Recommendation Report for Planning Permission for Works or Extension to a Dwelling

REF NO: R/255/14/HH

LOCATION: 3 Central Avenue
Rustington

PROPOSAL: Part pitched/part flat roof over side extension in place of previously approved flat roof (resubmission following R/92/14/HH)

Elevations (1:100)

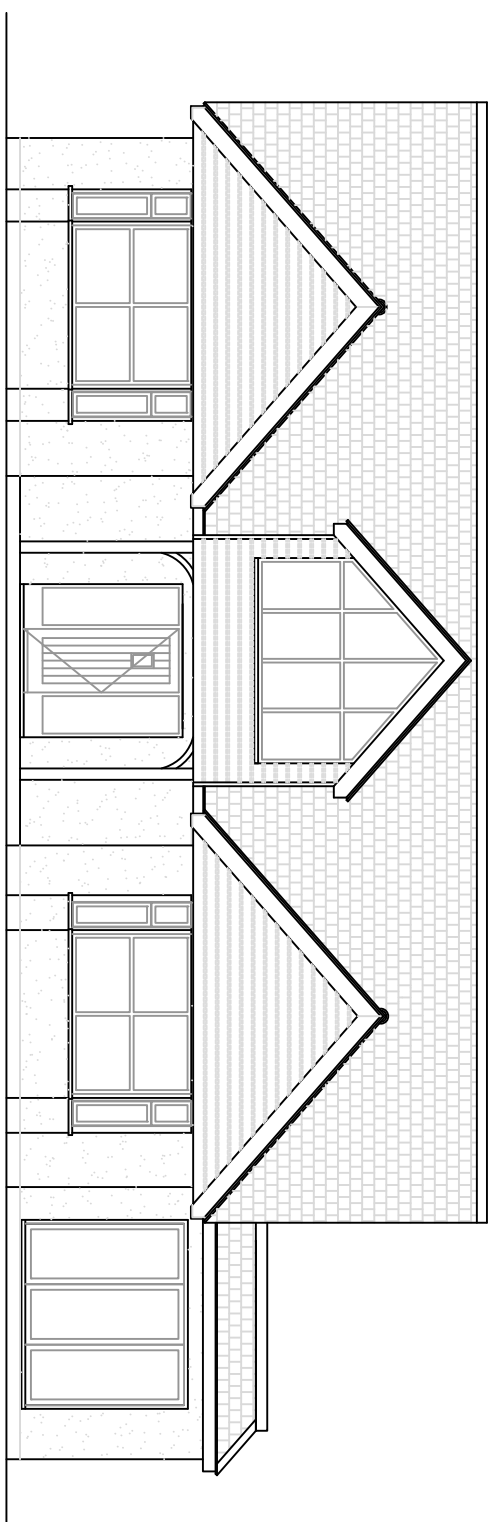
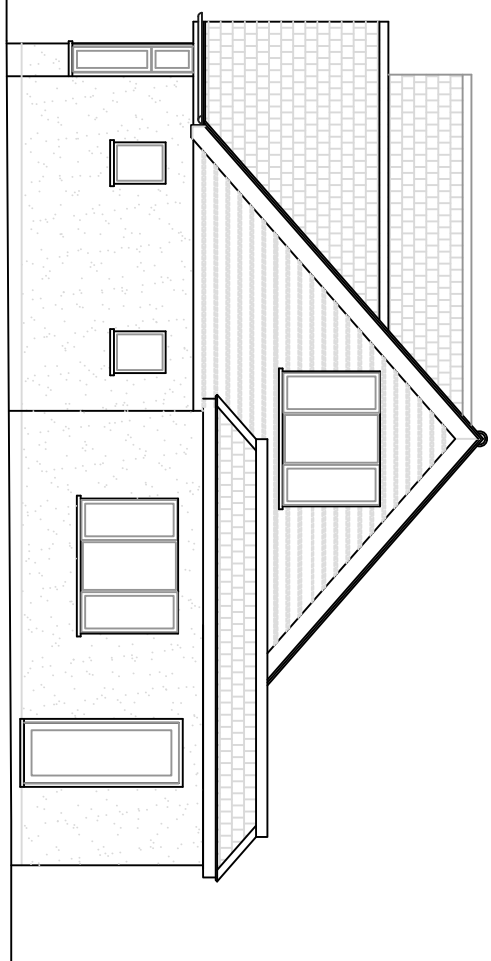
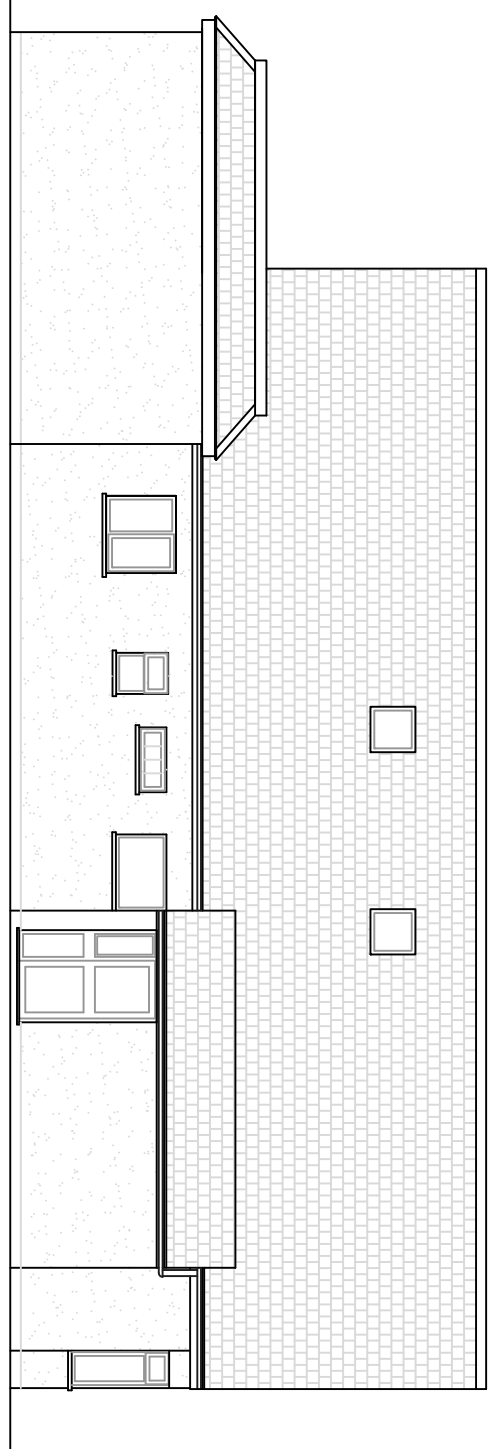
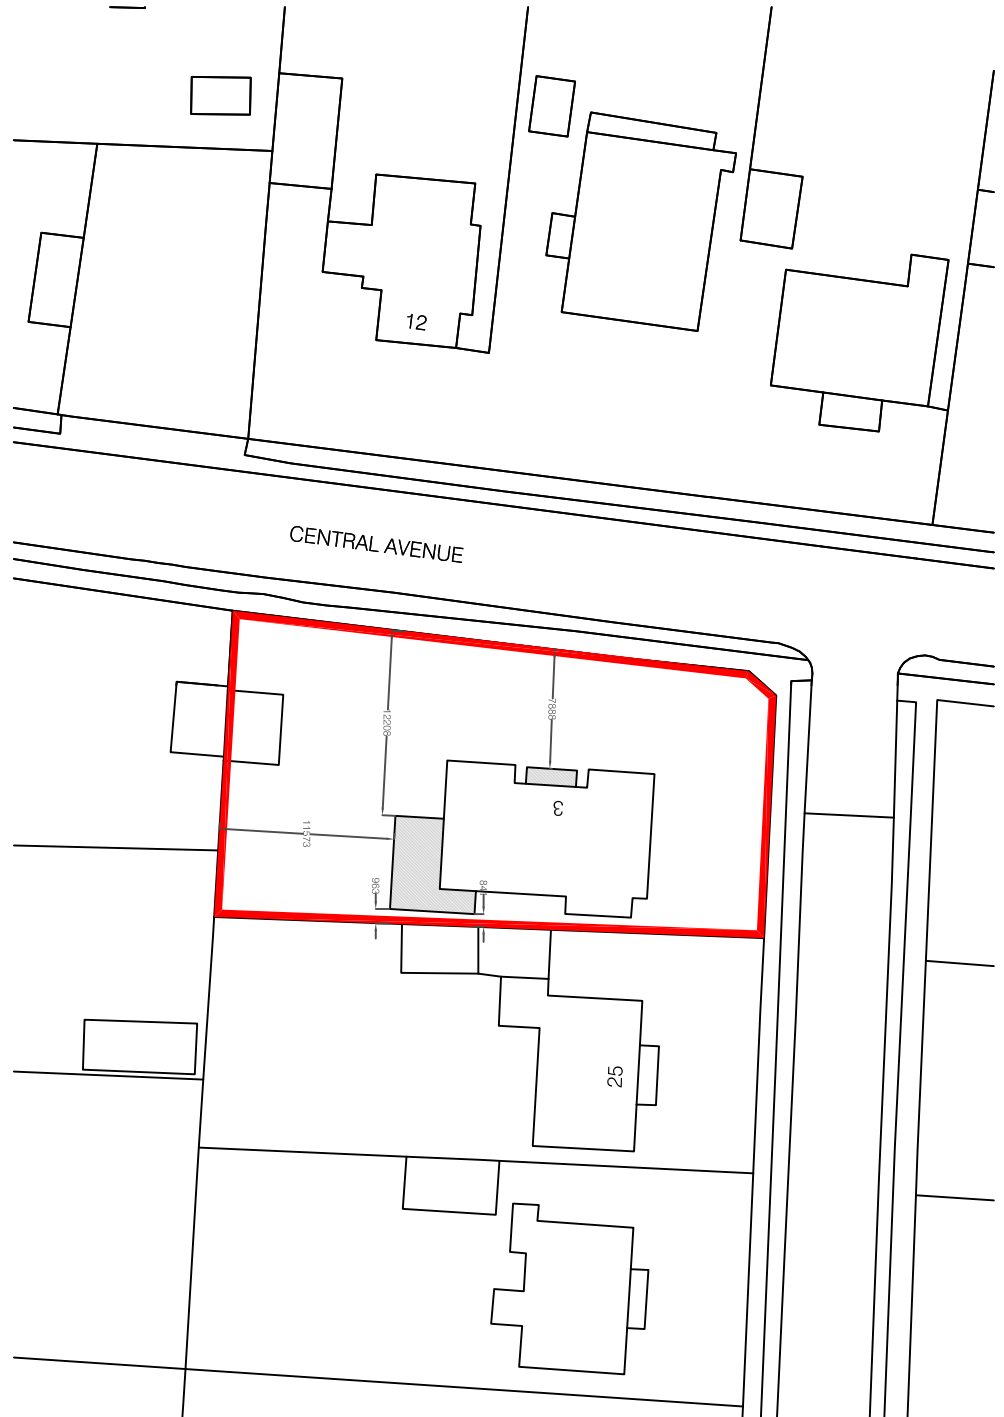
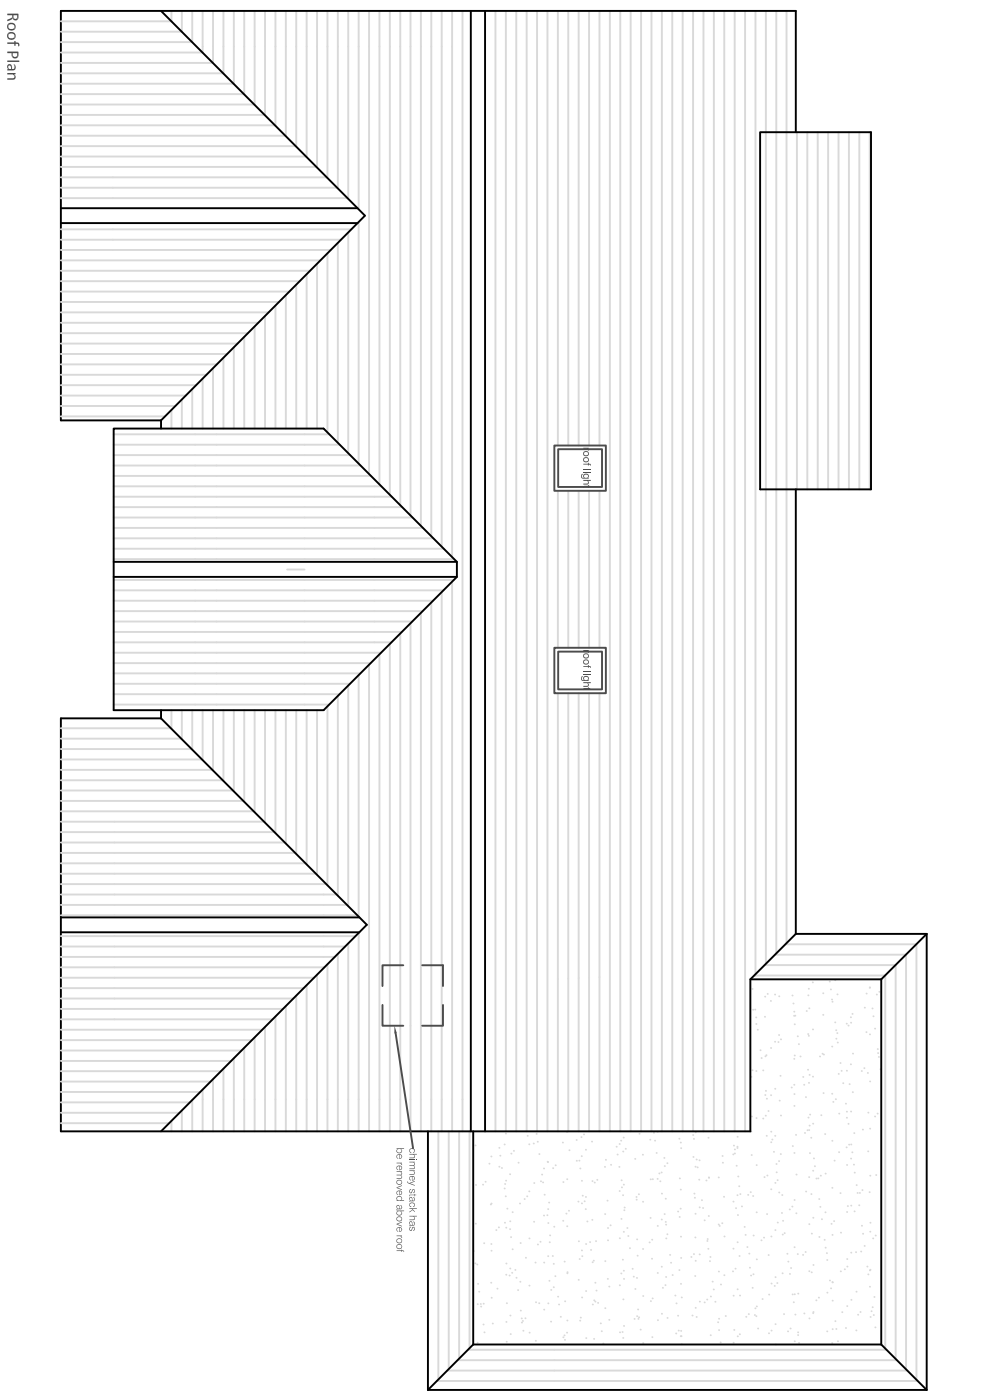
The application relates to an amendment to a recent planning approval R/92/14/HH which granted permission for the existing dwelling to be extended. The area of the proposal concerns the single storey extension on the south east corner of the dwelling. The application seeks permission to alter the approved flat roof to a false pitch. The maximum height of the roof would be 3.3m. It extends for a length of 5.3m and projects 1.9m from the rear elevation.

Whilst some light would be lost to the adjoining garden this would not result in material harm given the eaves height of 2.5m and that the roof pitches away from the boundary. The single storey extension is adjacent to the neighbour's garage and is not located immediately next to an area used for sitting outside. The structure is increasing in height by 0.65m and the distance to the neighbour's boundary with the summer house that has been carefully sited is 15m, which equates to the width of the intervening garden. Given this distance and the limited increase in height it is not considered that a materially adverse effect would result to neighbouring properties.

The proposed roof alteration would not be readily visible in the street scene since it would be located behind part of the existing dwelling which projects towards the eastern boundary. However the roof would be partially visible from the site frontage and a false pitch would improve its appearance.

The roof area is adjacent to the neighbouring boundary, providing a gap of less than 0.5m. It would have an eaves height of 2.5m and a would slope away from the boundary with a ridge height of 3.3m. The adjacent property to the east has a sloping roofed car port to the side boundary with a garage behind. A pitched roof structure projects beyond its rear elevation located adjacent to the proposed extension. Whilst the increased height of the extension would result in some loss of sunlight to the adjoining garden it is not considered that this would have a materially adverse effect on the residential amenities of the adjacent dwellings given its height and the presence of a pitched roof structure immediately adjoining the boundary.

- 2 The development hereby approved shall be carried out in accordance with the following approved plans 912.02.f.

- 3 The materials and finishes of the roof of the extension hereby permitted shall match in colour and texture those of the existing buildings.
